From: Laura Gibbons
Sent: 17 April 2019 09:12
To: Planning.Responses
Cc: Amber Willard
Subject: RE: Planning Consultation on BN/1/19/DOC

Engineers Comments Regarding Condition 3- surface water drainage

APPLICATION **BN/1/19/DOC**
NO:

Description of Approval of details reserved by condition imposed under
Works: BN/53/18/HH relating to conditions 3-surface water drainage &
4-discharge of any flows to watercourses.

Project:	37 Hill Lane, Barnham	Date:	Jan 2019	Made by:	KS	Sheet No.	1
CALCULATION SHEET		Job No.	1870	Chkd:	-	Rev.	0

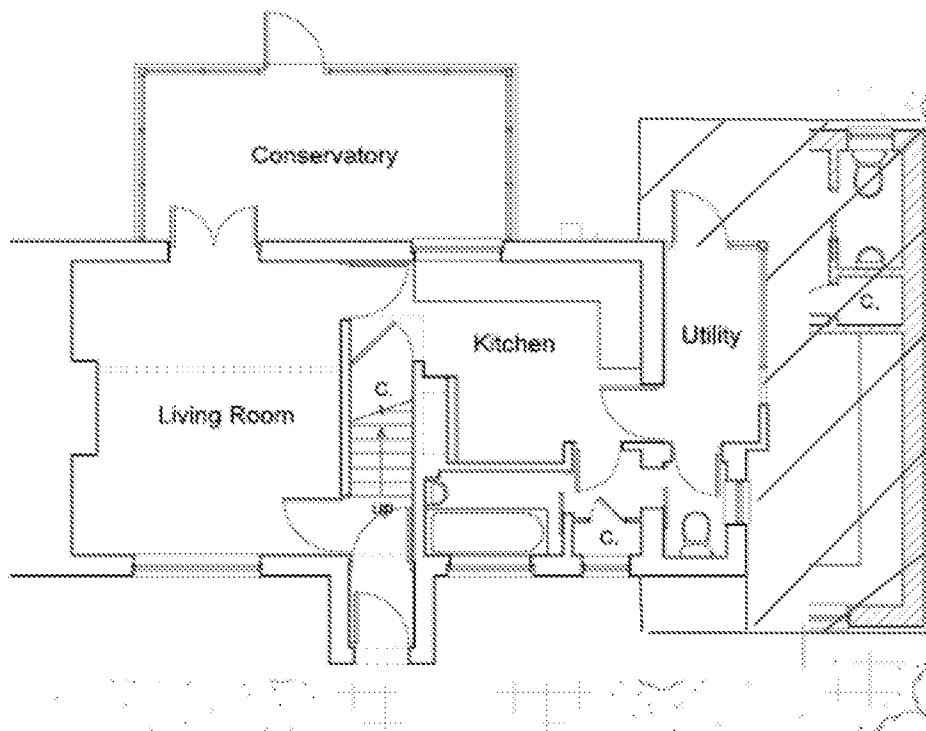
The previously supplied design stated that infiltration rates of 1×10^{-6} to $3.5 \times 10^{-7} \text{ ms}^{-1}$ were found. Yet the revised design states that an infiltration rate of $4.17 \times 10^{-4} \text{ ms}^{-1}$ was found. It is unclear how such a vast improvement in infiltration rates was found. Knowing the area well I do not believe infiltration rates will be this good, the initial rates found are far more in keeping with the underlying strata and surrounding results.

Project:	37 Hill Lane. Barnham	Date:	Mar 2019	Made by:	KS	Sheet No.	1
CALCULATION SHEET		Job No.	1870	Chkd:	-	Rev.	0

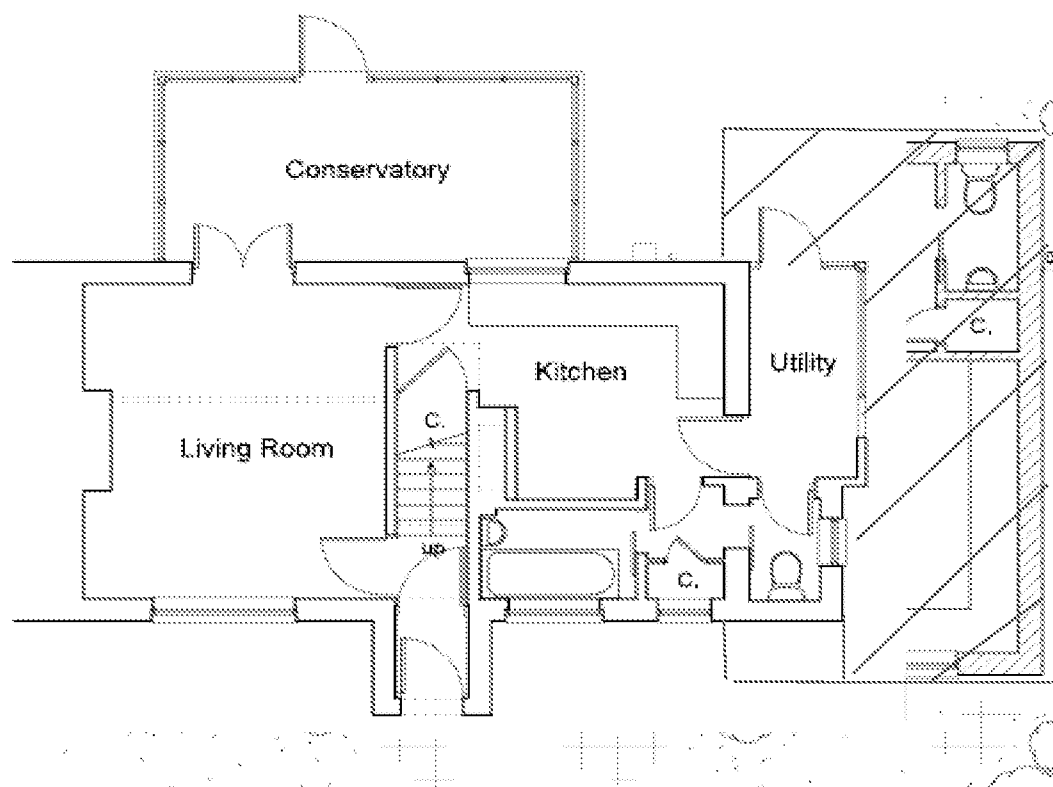
Can the applicant please provide further information on the testing completed. I.e. photos and record sheets. A location plan showing the location of groundwater monitoring and infiltration testing must be provided.
